**Consultation Response from KC,
Highways Development Management****2021/90474 Land Adj, 3, The Copse, Scholes Lane, Scholes, Cleckheaton, BD19 6NE****Erection of detached dwelling with integral garage (within a Conservation Area)****Date Responded:
08/04/2021****Responding Officer: Zack
Turner****Responding Ref: 7-4SE-4**

2021/90474

*block plan*  
SCALE 1:500

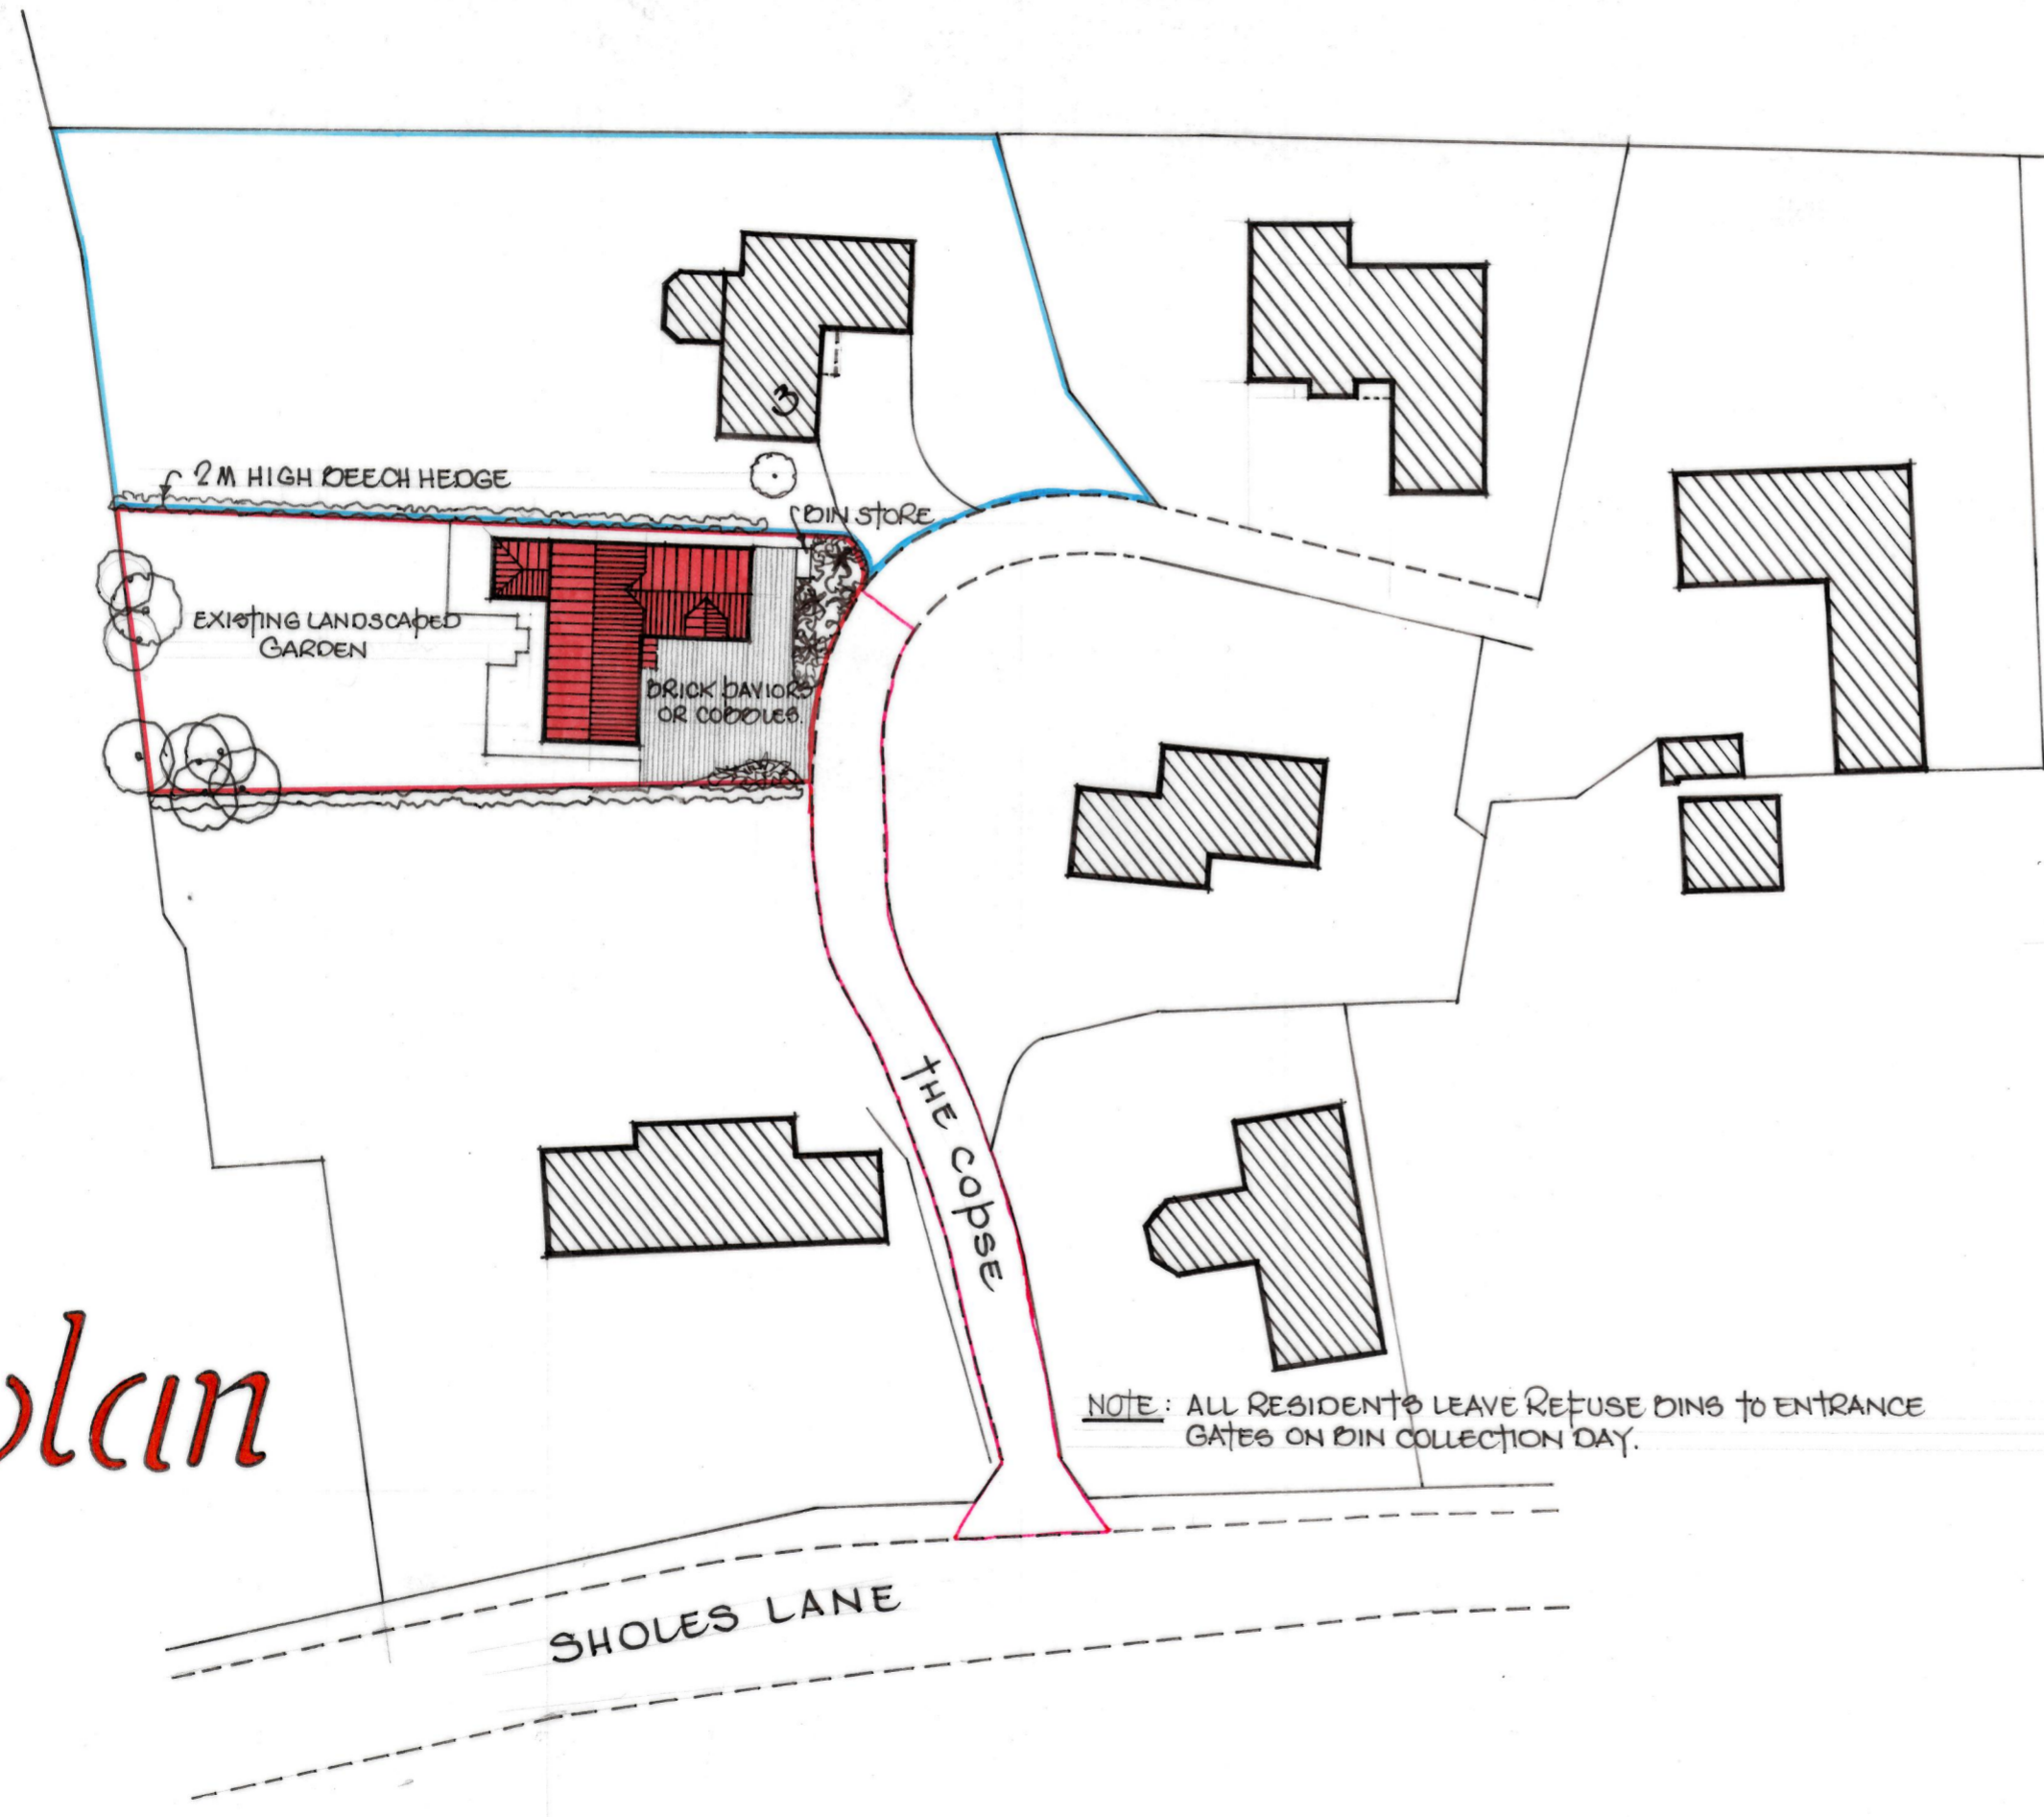
The Copse currently serves 5 dwellings and it is an unadopted road. In accordance with the Kirklees Highways Design Guide private drives that serve more than 5 dwellings should be made to adoptable standards so they can be adopted by the council.

There will be an intensification of use at the access of The Copse from Scholes Lane and this access is 3.8m wide so therefore it is not suitable to serve the additional development without significant improvement to the access. Additional advice can be found in Kirklees' Highway Design Guide SPD.

HDM are unable to support the application in its current form and requests more information as stated above for a proper assessment of the proposals.
